+158 Acre Parcel
168 Training Facility

LANDSCAPE PLAN

MVE PROJECT 61224
MVE DRAWING DEV-LS

OCT.30, 2024
SHEET 1 OF 1

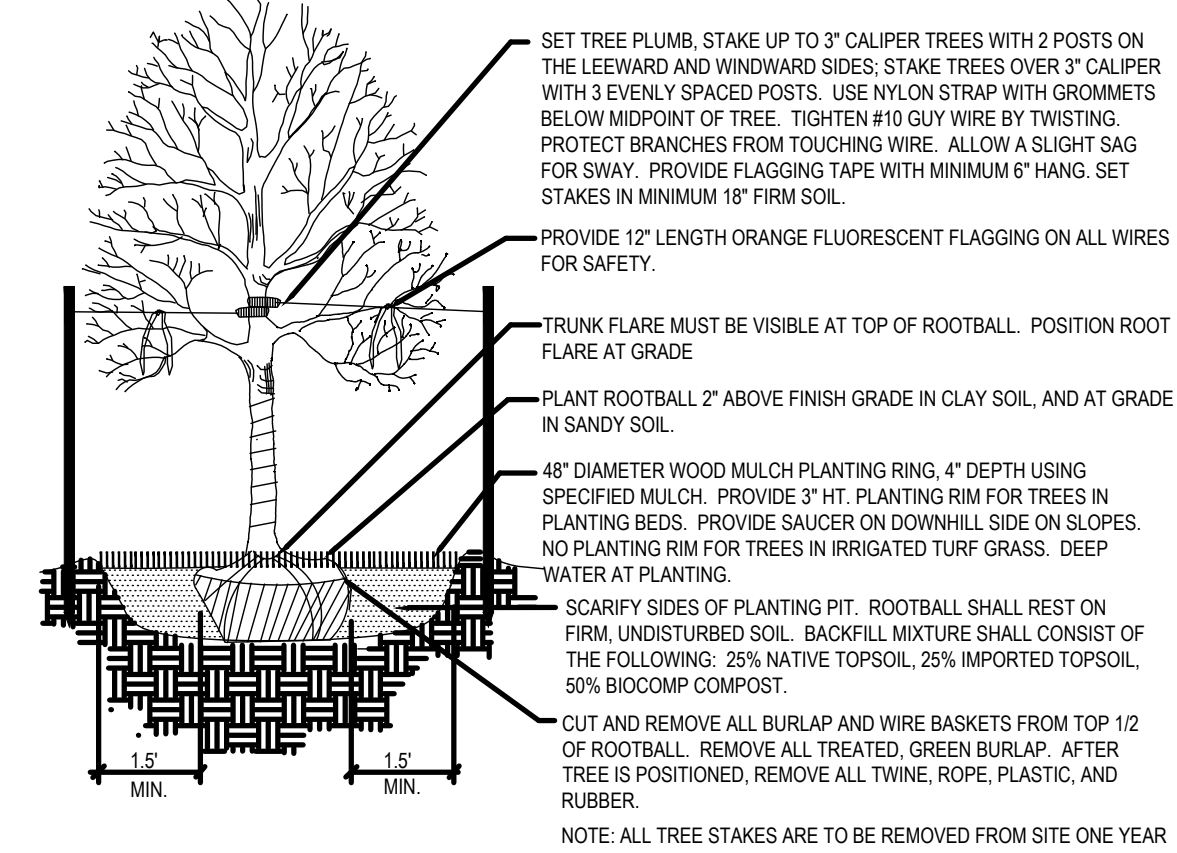
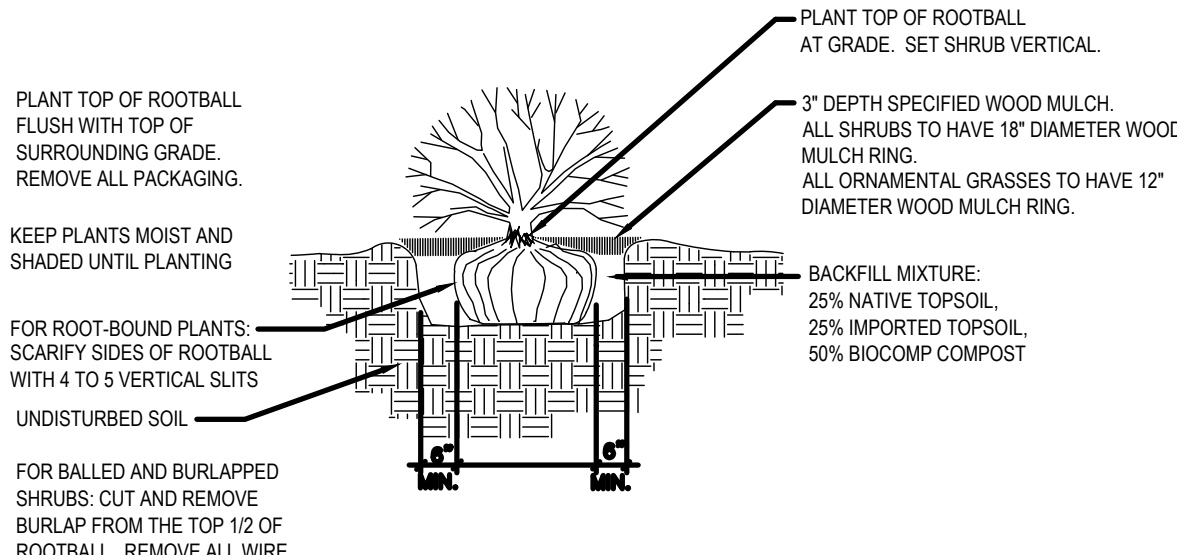
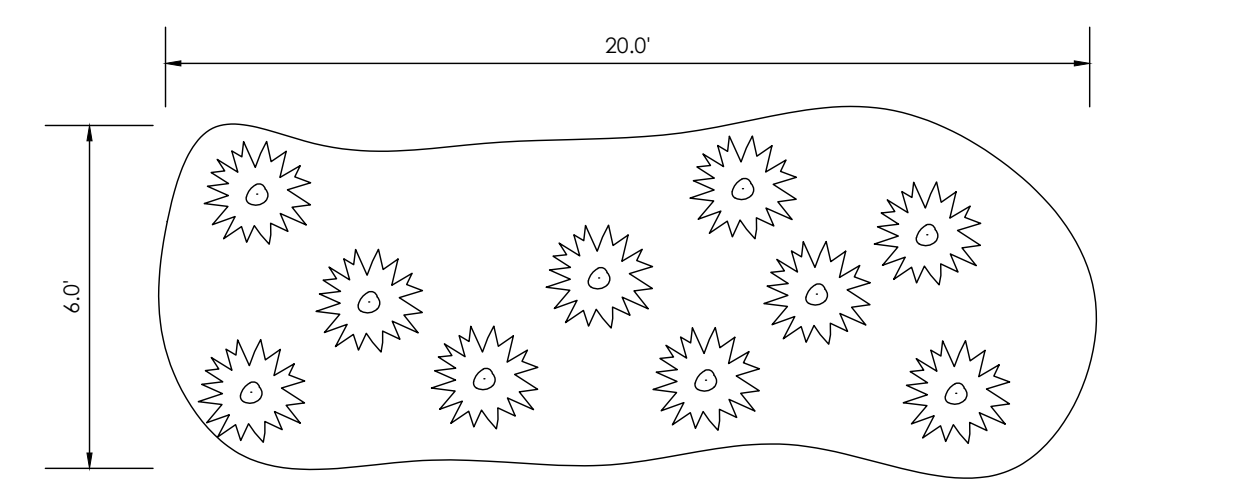
See Section 6.2.2.E. in the Land Development Code for details about Internal Landscaping requirements.

If you cannot meet this requirement please discuss the justification for your alternative plan in the Letter of Intent

Per Section 6.2.2.C.1. in the Land Development Code, a tree of a type suitable for parking lots shall be provided for every 15 parking spaces in parking lots with 15 or more parking spaces. The required trees may be clustered and shall be located in a manner which will divide and break up expanses of paving and long rows of parking and create a canopy effect over the parking lot.

If you cannot meet this requirement please discuss the justification for your alternative plan in the Letter of Intent

S. Calhan Hwy is a Minor Arterial Roadway which requires 1 tree per 25 feet and has a 20 foot depth of roadway landscaping area.

If you cannot meet this requirement please discuss the justification for your alternative plan in the Letter of Intent

The GEC Plans reference seeding and mulching to be per the approved landscaping plans. I do not see seed mix and mulching specifications or limits on these plans. Please clearly delineate seeding and mulching limits so it is clear all areas will be stabilized.
